Case Officer: Laura Bell

Recommendation: Approval

Applicant: Albion Land

Proposal: Non-material amendment to 21/03177/F - Application to amend the wording of condition 8 to reflect the required Tree Protection and Retention Plan

Document title
TREE RETENTION AND PROTECTION PLAN

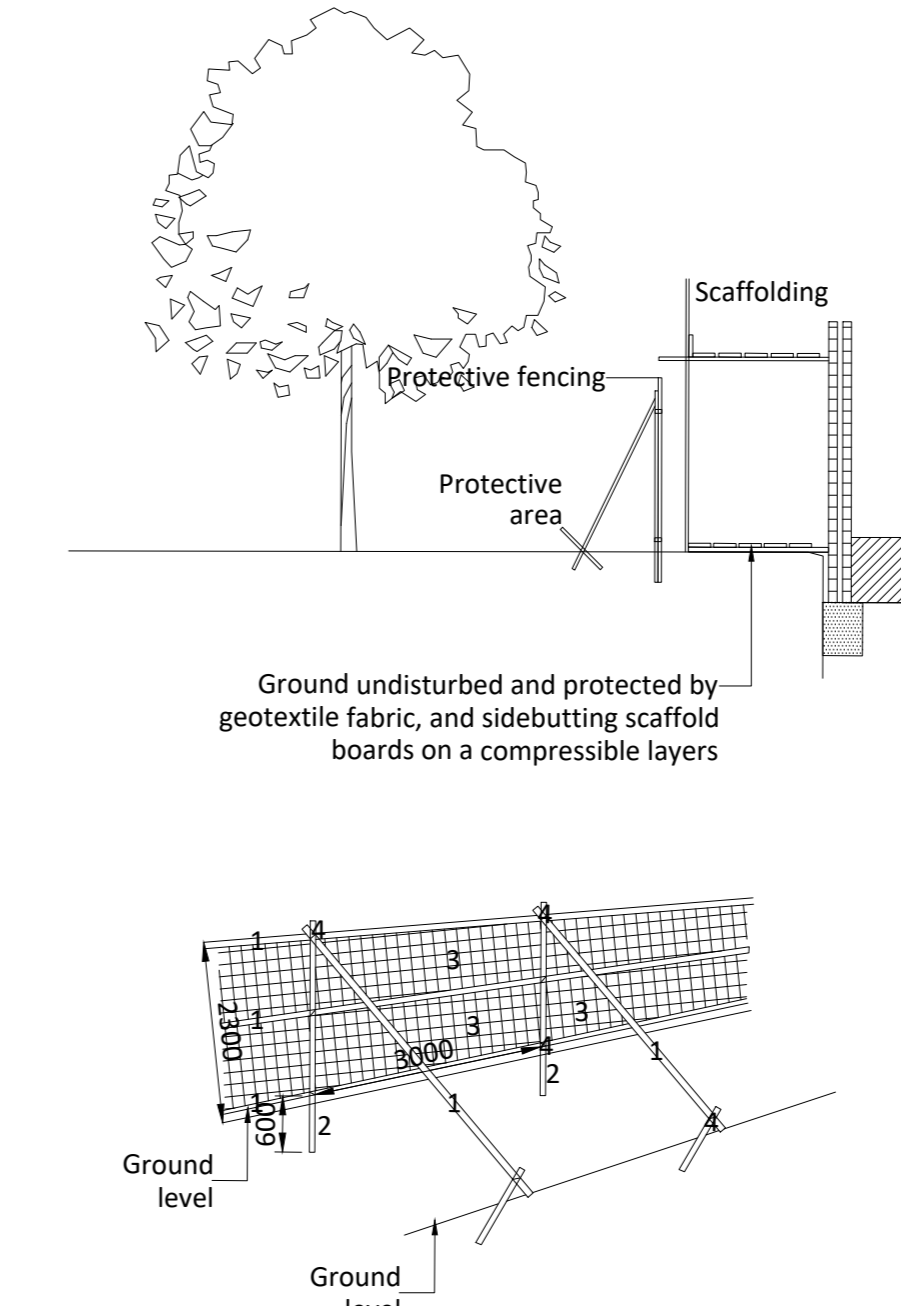
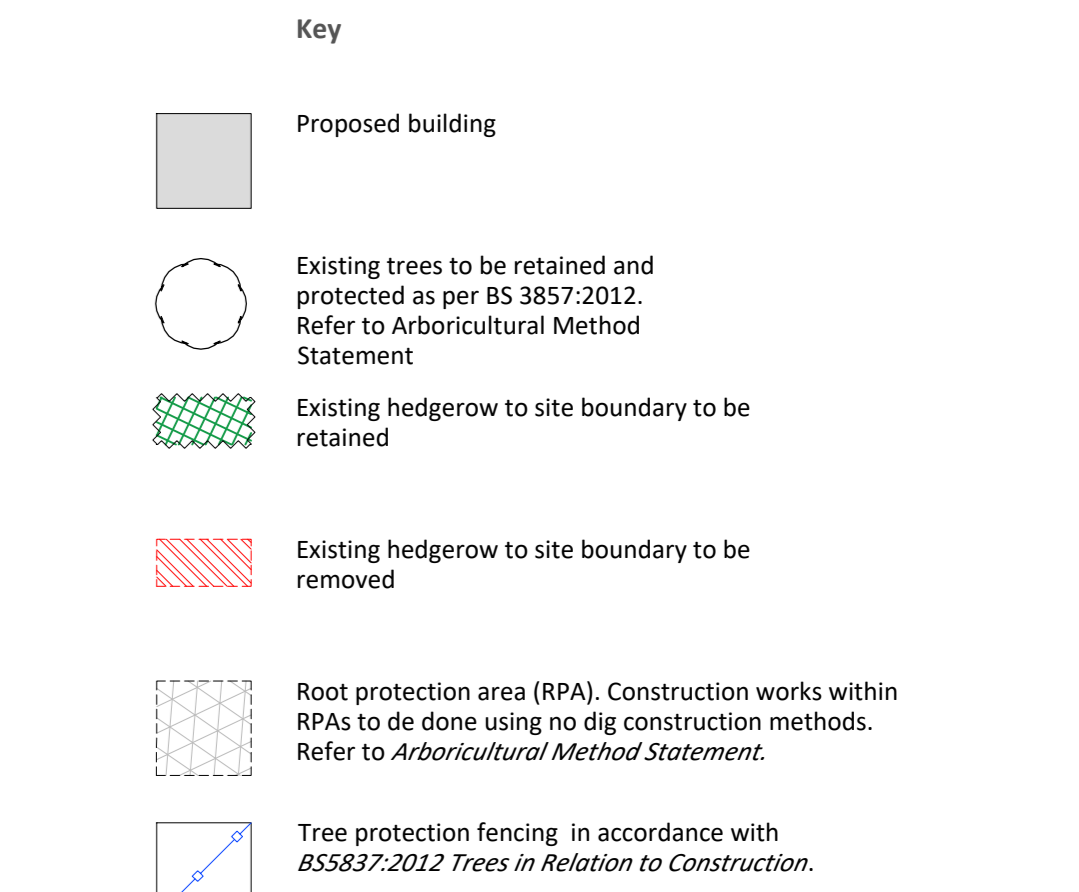
- 5.4. The submission has been made in response to the S278 process, which identified that OCC has a requirement for greater visibility for pedestrians at the pedestrian crossing on Howes Lane. In order to provide this, 6 metres of hedgerow along Howes Lane needs to be removed. The Tree Retention and Protection plan approved as part of condition 8 states the following:

As such, the wording of the above condition needs to be amended to reflect the amended Tree Retention and Protection Plan.

- 5.5 The changes are required in order to satisfy the highway safety requirements of the S278 agreement. They are relatively minor in nature, but in any case, the highway safety requirements are considered to outweigh any minor detriment to the visual amenities of the immediate locality.
- 5.6 The arboricultural technical note submitted confirms that the conclusions and protection measures of the approved arboricultural method statement remain the same.
- 5.6 As such, it is considered that the wording of condition 8 be amended as follows:

No development shall take place until any existing trees or vegetation to be retained have been protected in accordance with the approved Tree Retention and Protection Plan drawing number 0897-RFM-XX-00-DR-L-0005 P05, Arboricultural Technical Note ref: 10706_R12 JP06072023 both received 17 July 2023 and Arboricultural Method Statement (TG Report No. 10706_R11a_RA_CW) dated 20 August 2021 unless otherwise agreed in writing by the Local Planning Authority. The barriers shall be erected before any equipment, machinery or materials are brought onto The Site for the purposes of development and shall be maintained until all equipment machinery and surplus material has been removed from The Site. Nothing shall be stored or placed within the areas protected by the barriers erected in accordance with this condition and the ground levels within those areas shall not be altered, nor shall any excavations be made, without the written consent of the Local Planning Authority.
